8 February 2018

**SECTION 96(1A) MODIFICATION APPLICATION TO SSD 7445
SITE 9, OLYMPIC BOULEVARD, SYDNEY OLYMPIC PARK (SSD 7445)**

This application has been prepared by Ethos Urban on behalf of Ecove Group Pty Ltd, seeking amendment to State Significant Development (SSD) 7445 pursuant to Section 96(1A) of the *Environmental Planning and Assessment Act, 1979* (EP&A Act) seeking consent to modify the internal configuration of the development, new plant and changes to the facade at Site 9, Olympic Boulevard Sydney Olympic Park address (the site).

Proximity to Rail Corridor Site Plan +
Building Envelope

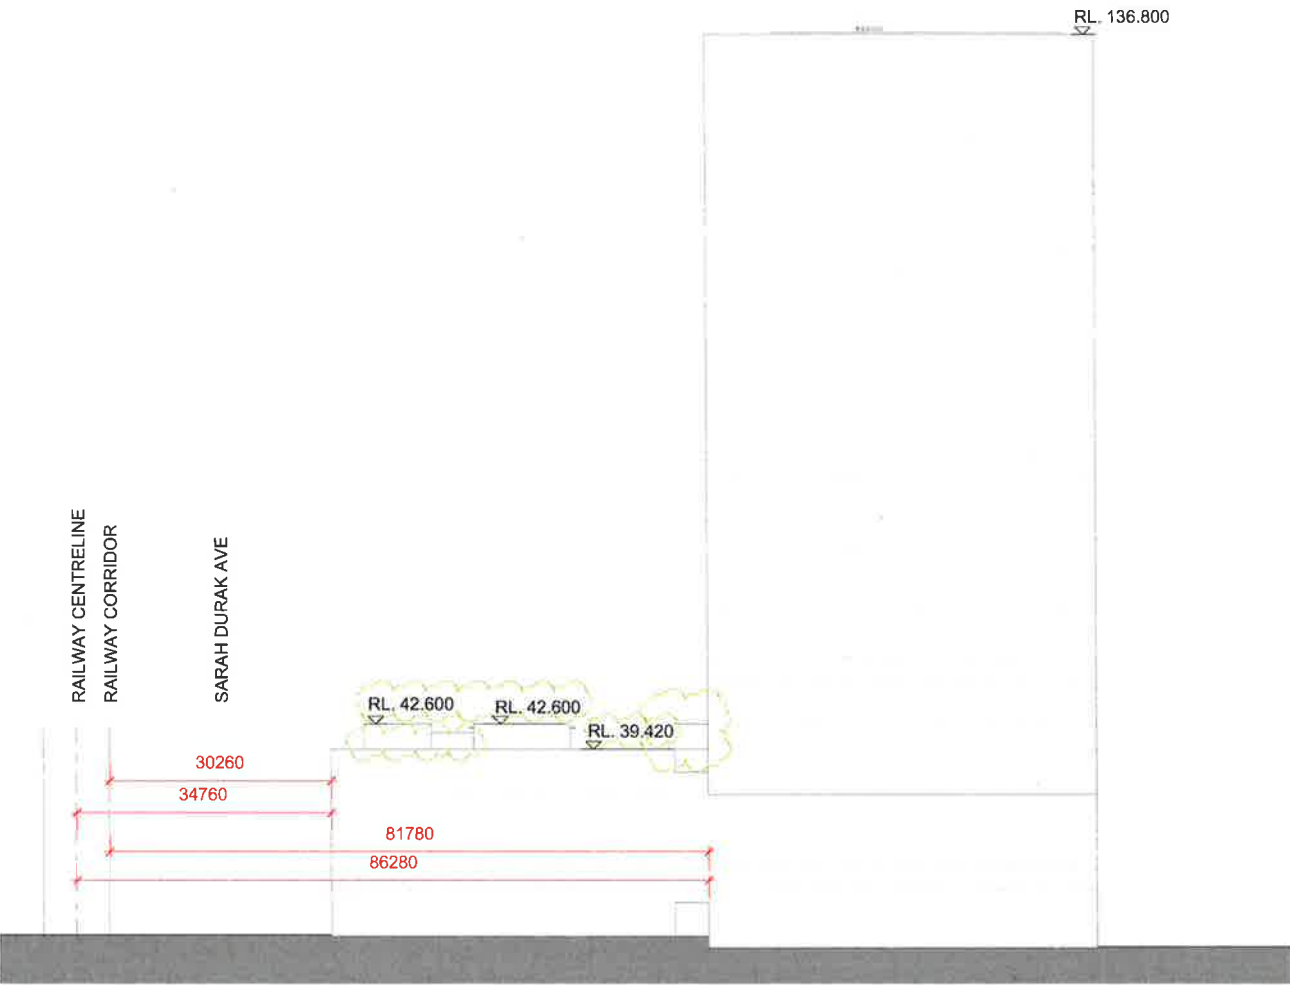
The reconfiguration of the communal roof top includes deleting the eastern pavilion (shown in **Figure 7**), two new plant rooms, minor modifications to the benches and landscaping (shown in **Figure 8** and **9**). In addition, the application is seeking to modify the proximity to railway plan to amend the RL 42.8 of the northern roof to be consistent with the approved RL of 42.6 northern roof of the podium and amend RL 39.6 of the parapet north to be consistent with the approved RL of 39.42.

General Arrangement Plan
Ground

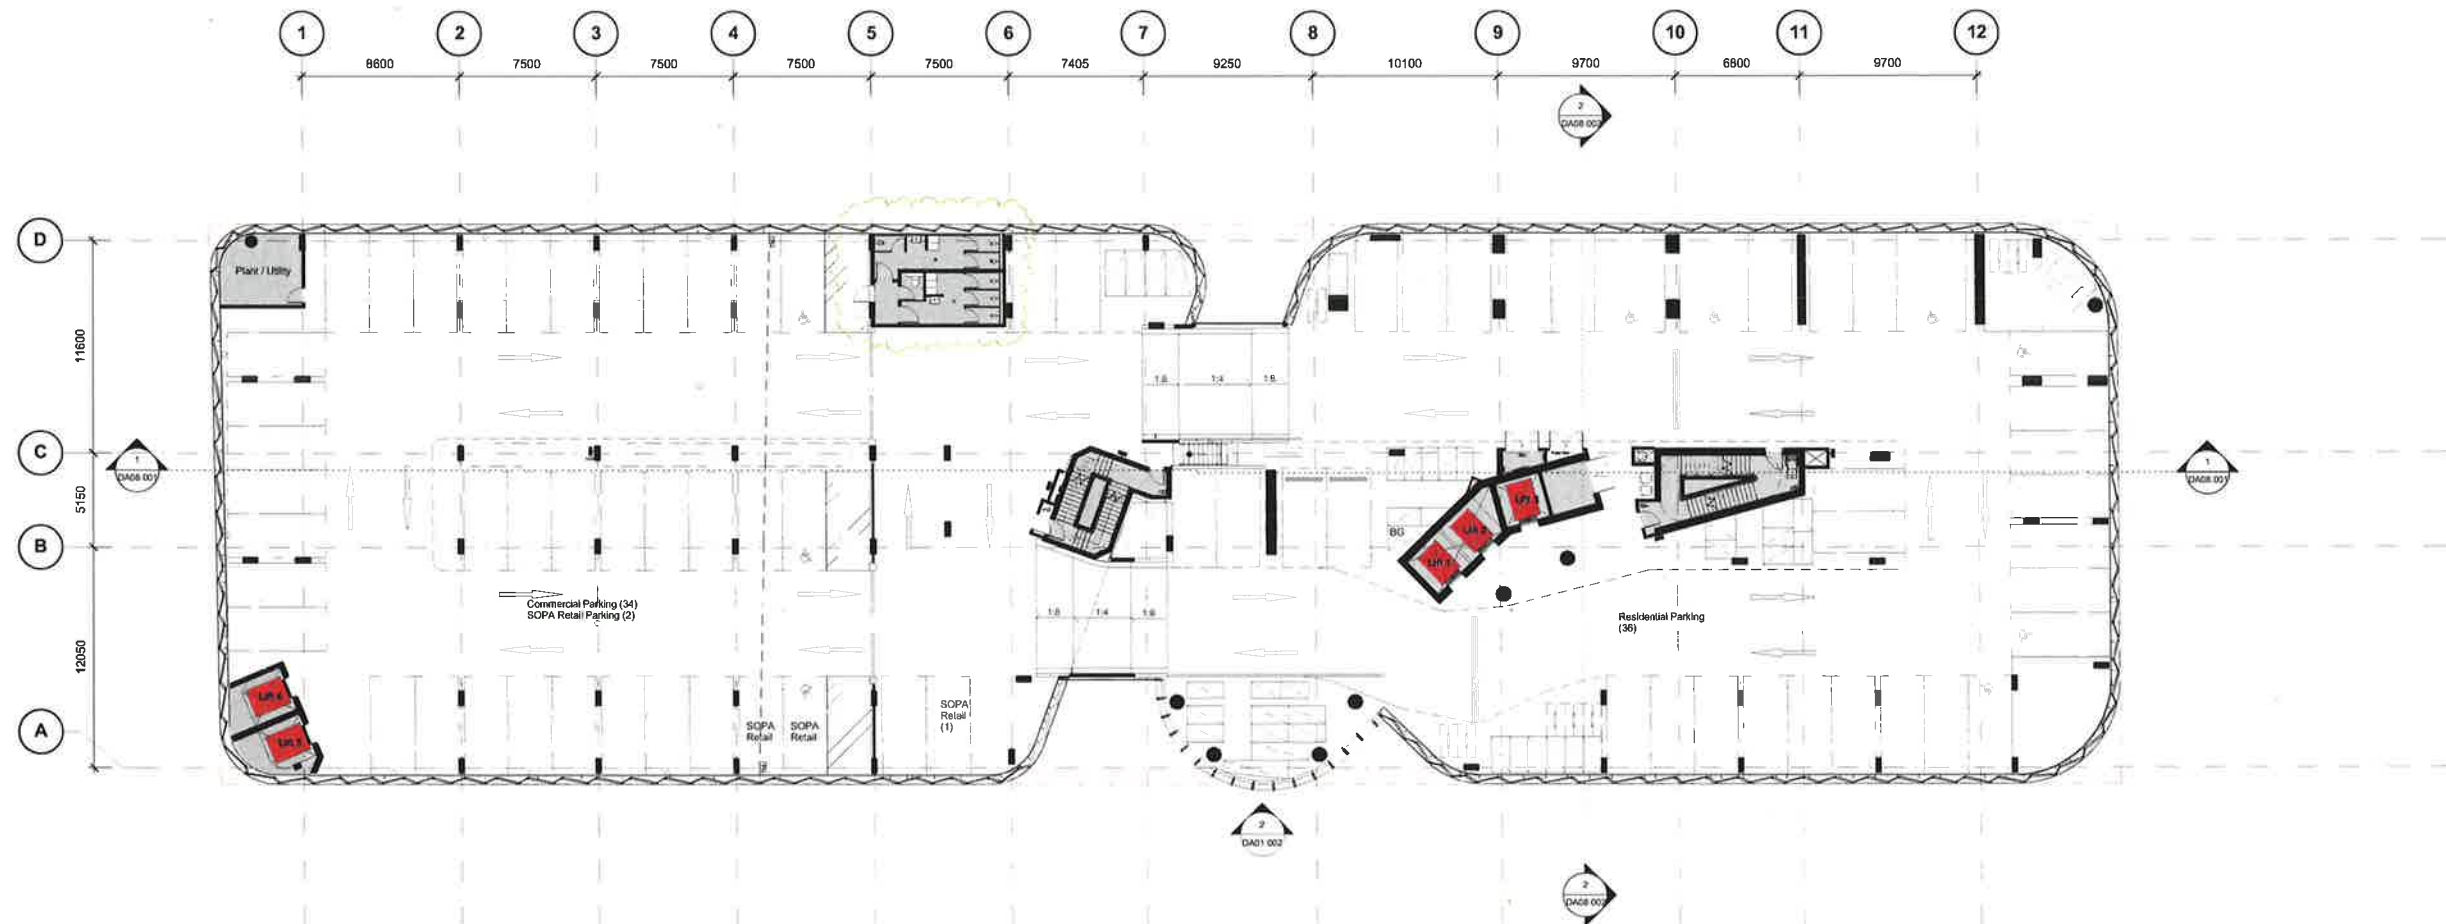
This application seeks to reconfigure the plant rooms to align with the preferable and optimal service requirements. The residential bike store has been relocated from the southern section of the ground floor (as demonstrated in **Figure 3**) to the northern section of the ground floor (as demonstrated in **Figure 4**). The locations of the retail intertenancy walls on the ground floor are subject to confirmation (as shown in **Figure 4**).

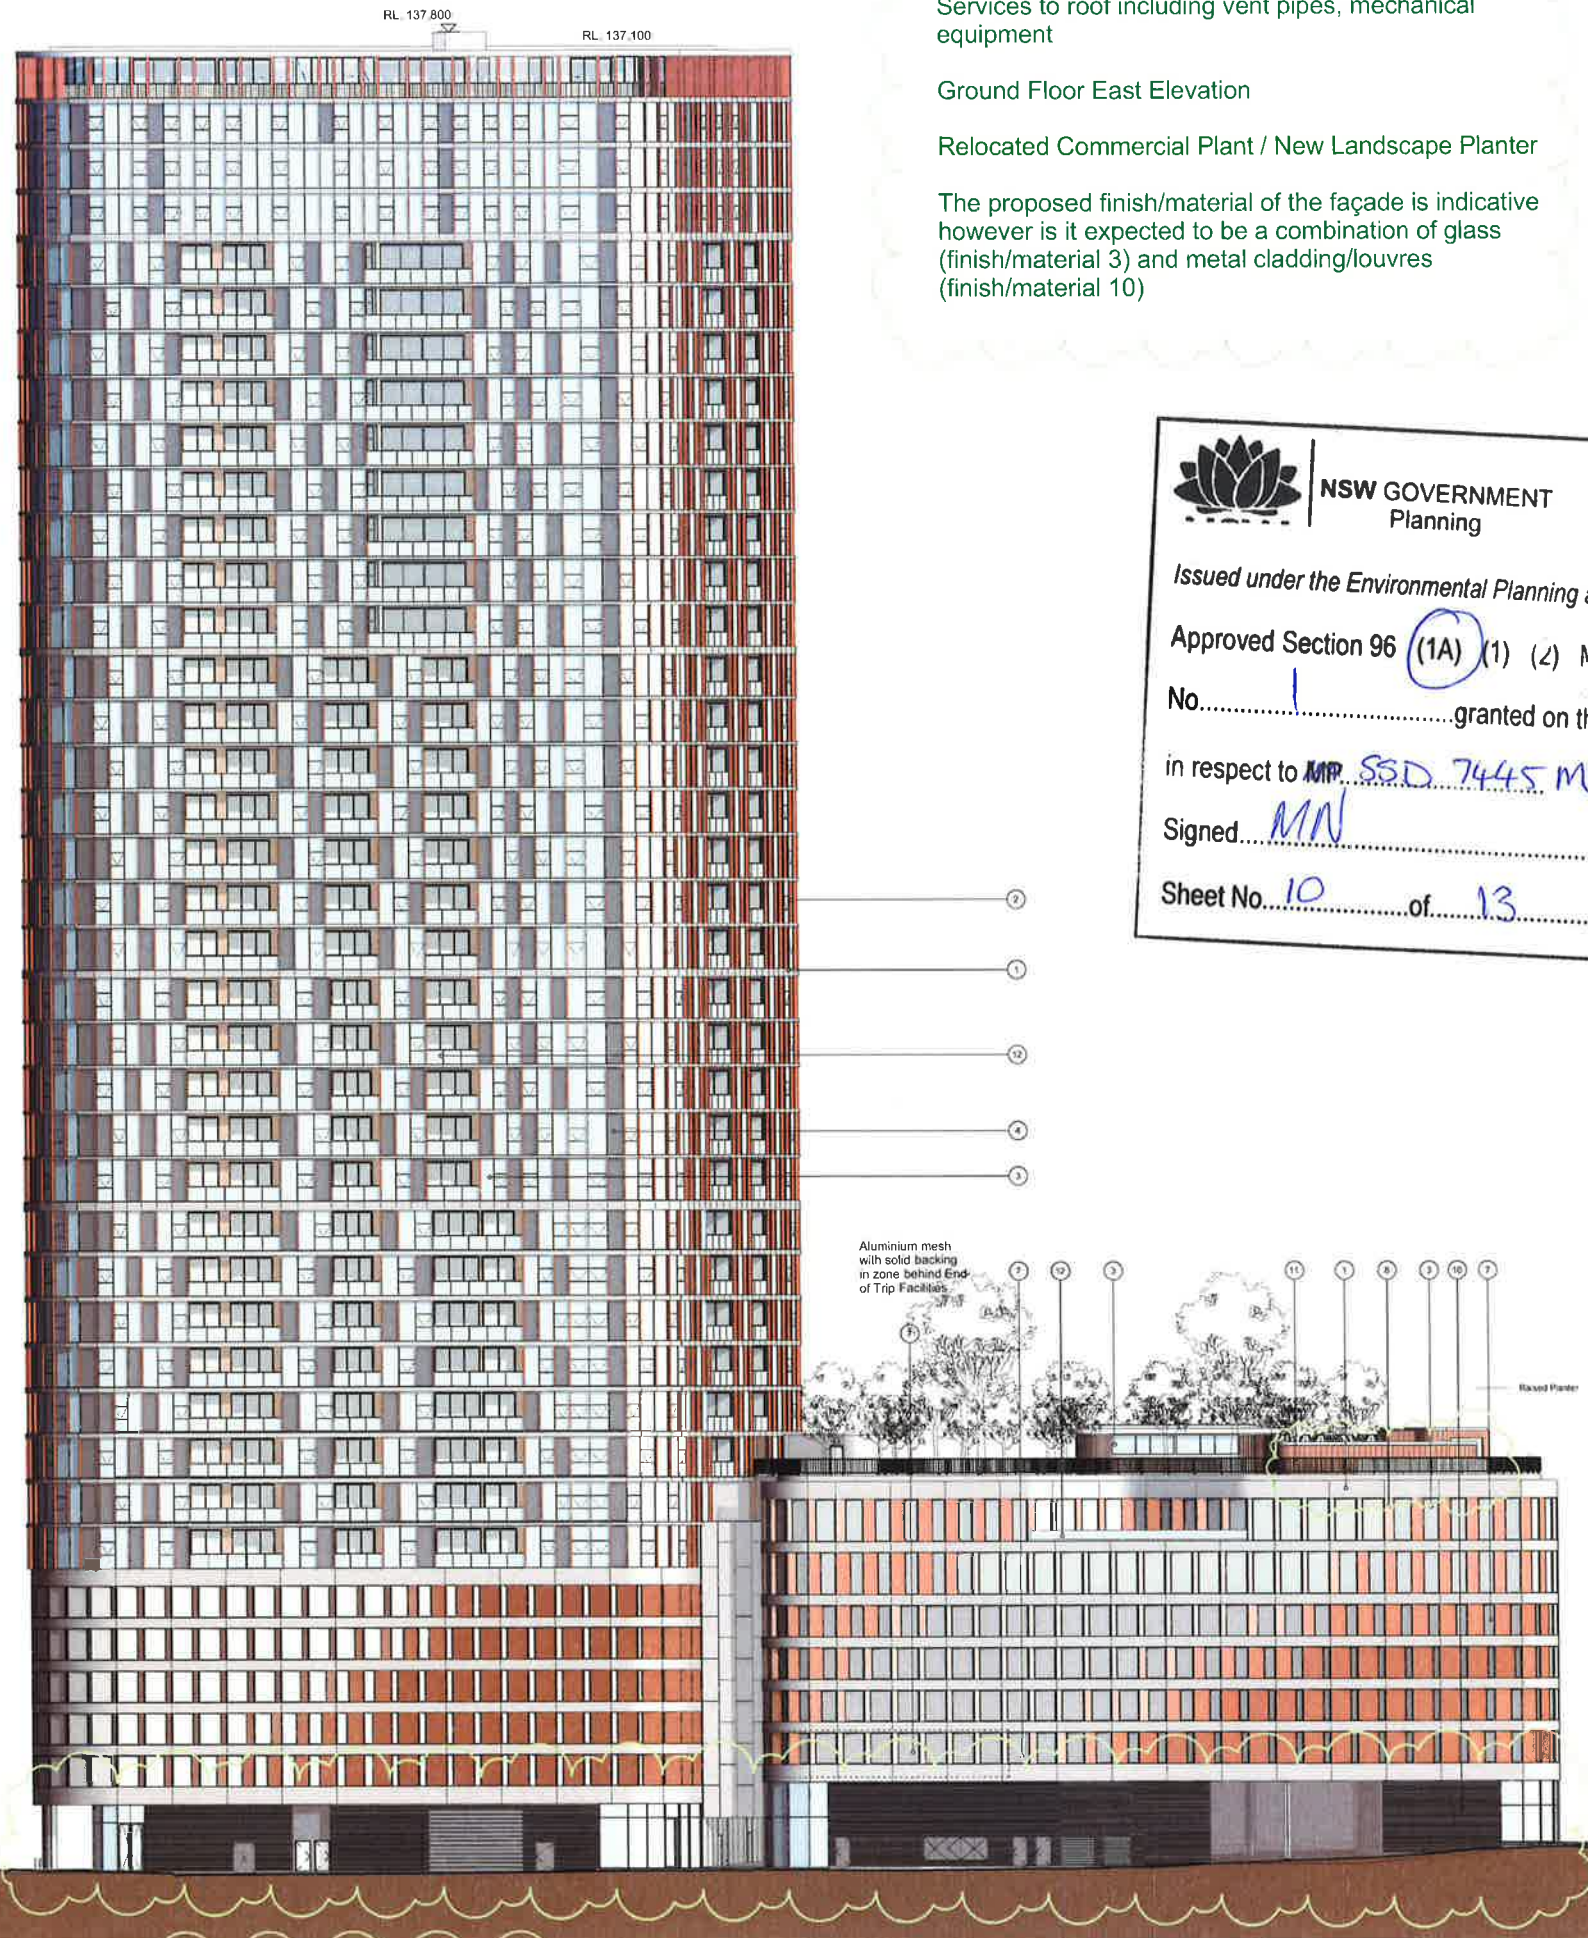
The proposal includes reconfiguration of the approved services on the roof and on level 39 (shown **Figure 17**), the reconfiguration of plant on level 39 consists of mechanical plant and the reconfiguration of the plant on the roof consists of vent pipes and mechanical equipment (shown in **Figure 18**).
